App no: 23.0812

Address: Old Row Whalley Road Barrow

Proposal: Approval of details reserved by conditions 5 (surface water drainage), 6 (construction drainage plan), 7 (surface water operation and maintenance manual), 10 (construction method statement), 13 (travel plan), 19 (pedestrian link), 20 (bird and bat boxes and hedgehog features) and 24 (external materials) of planning permission 3/2023/0153.

ROOT PROTECTION PATH
SCALE 1:500

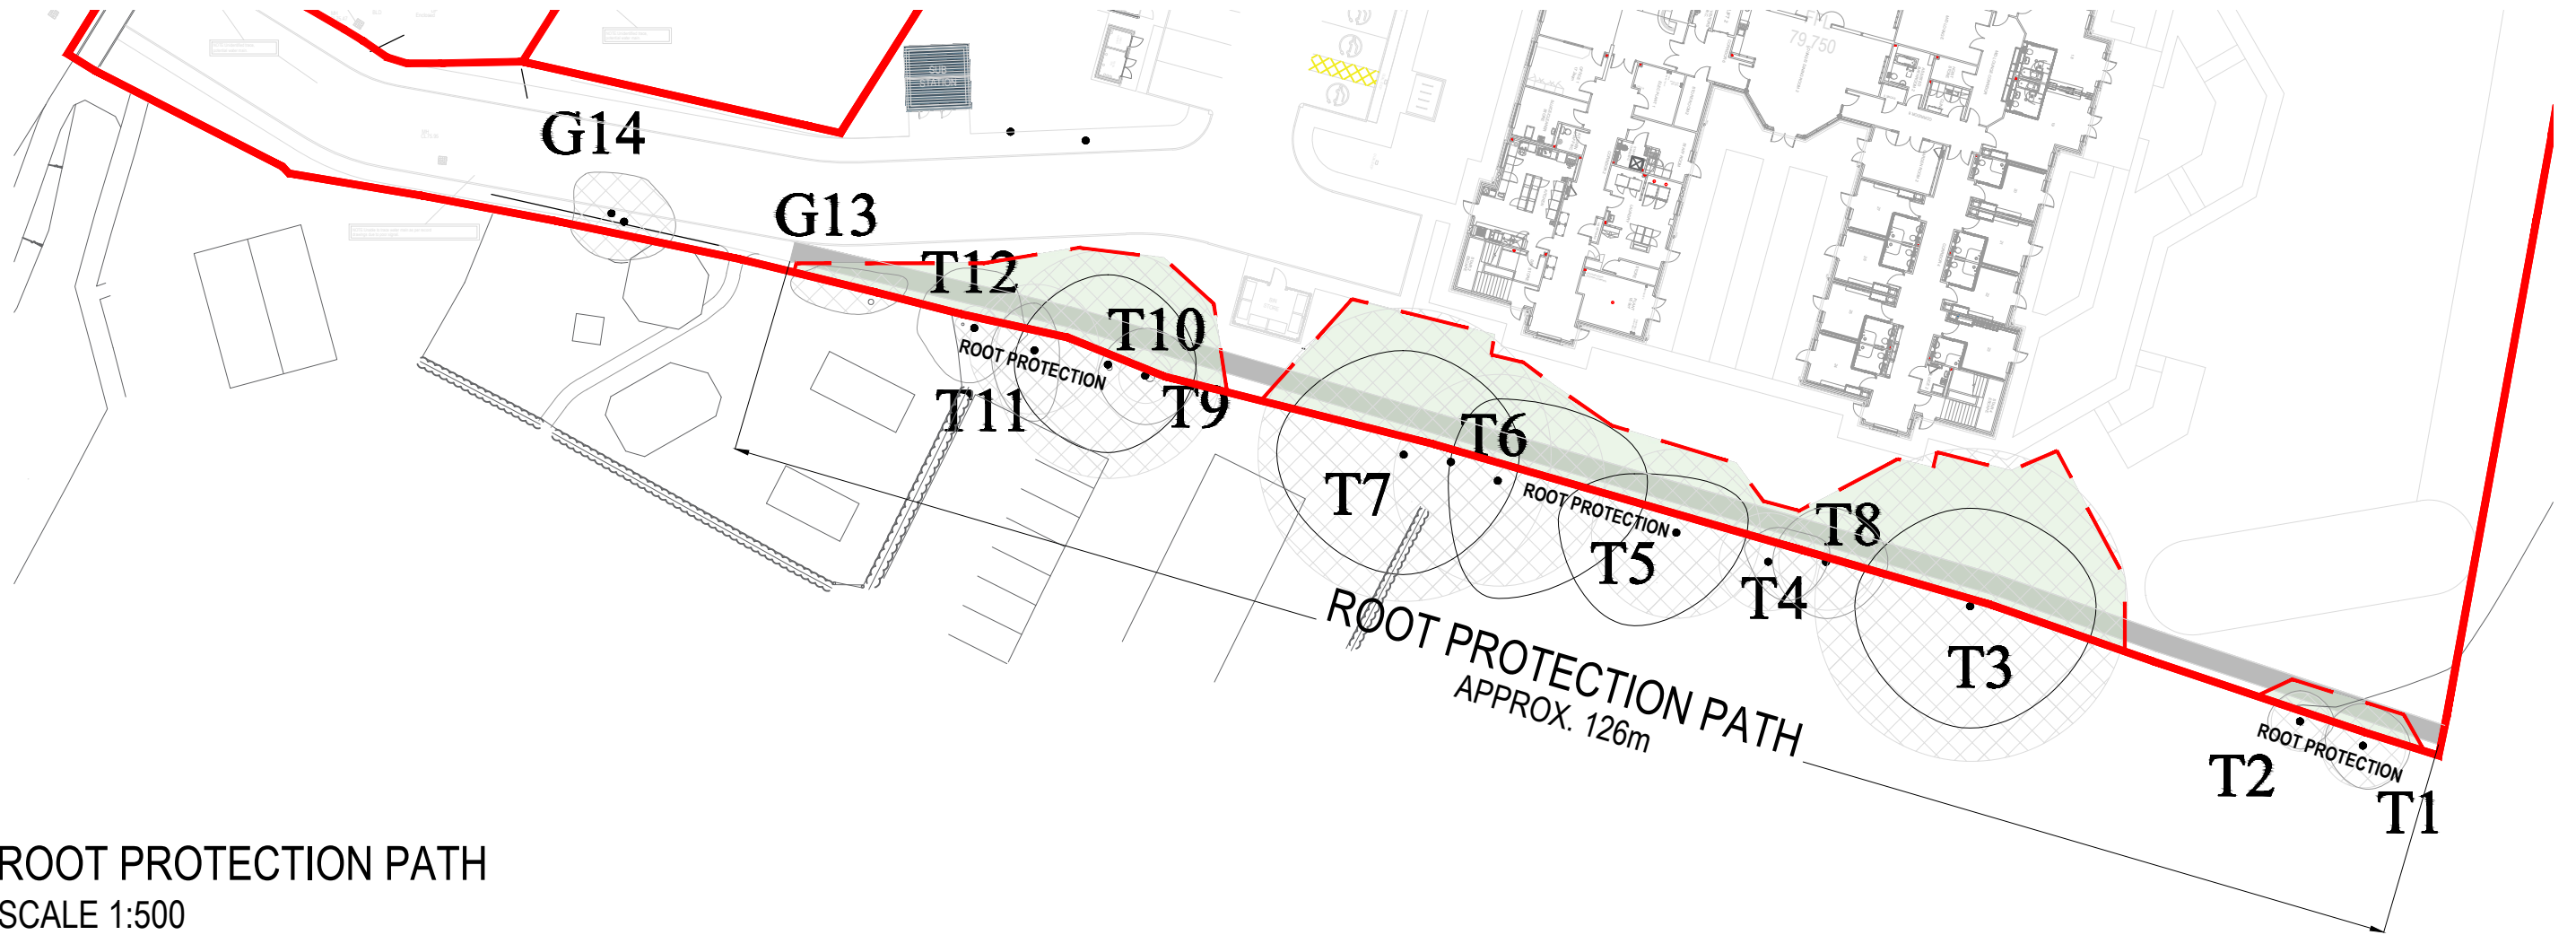
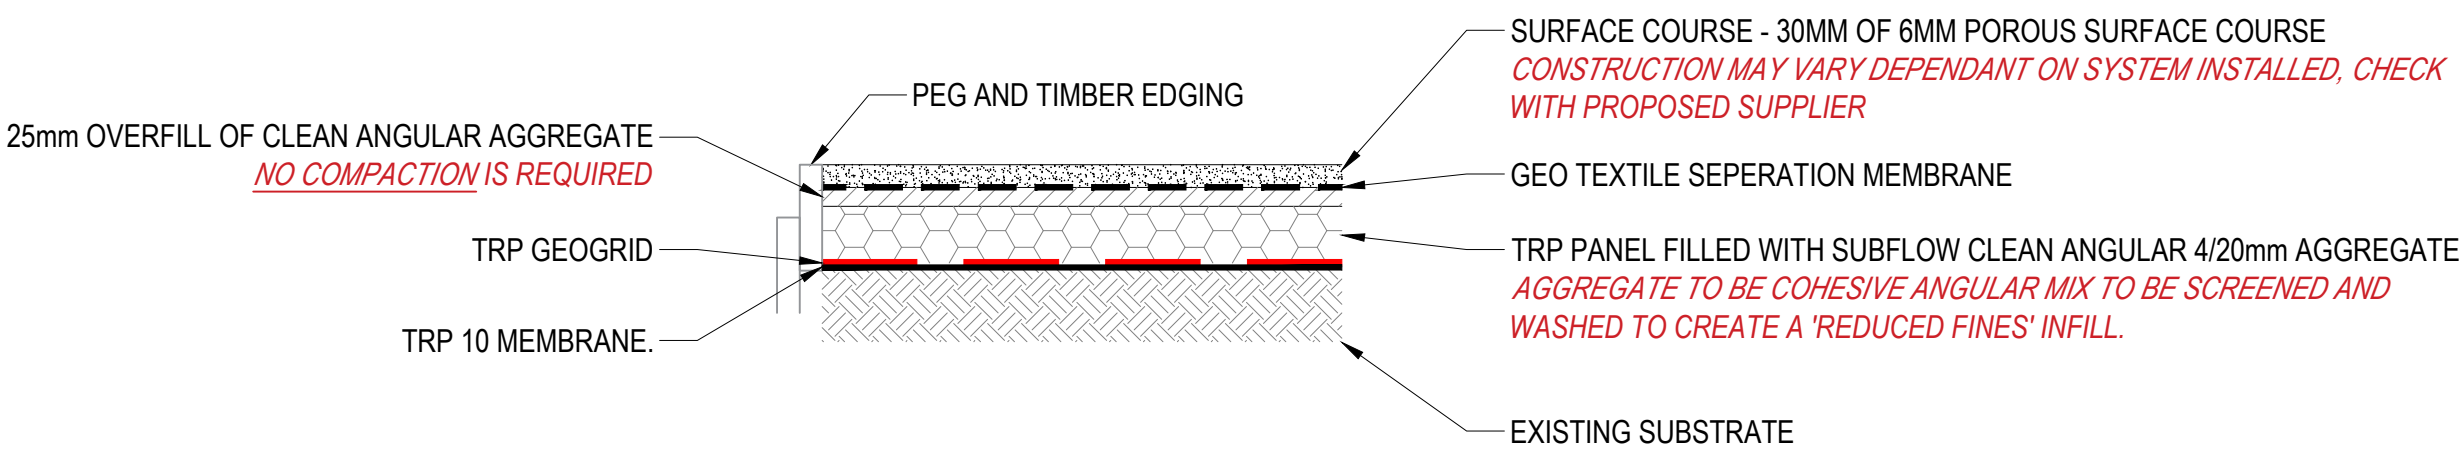
Condition 19 – Pedestrian link – There are no details regarding the construction methodology or surfacing of the link submitted.

Further details are requested to allow the discharge of this condition.
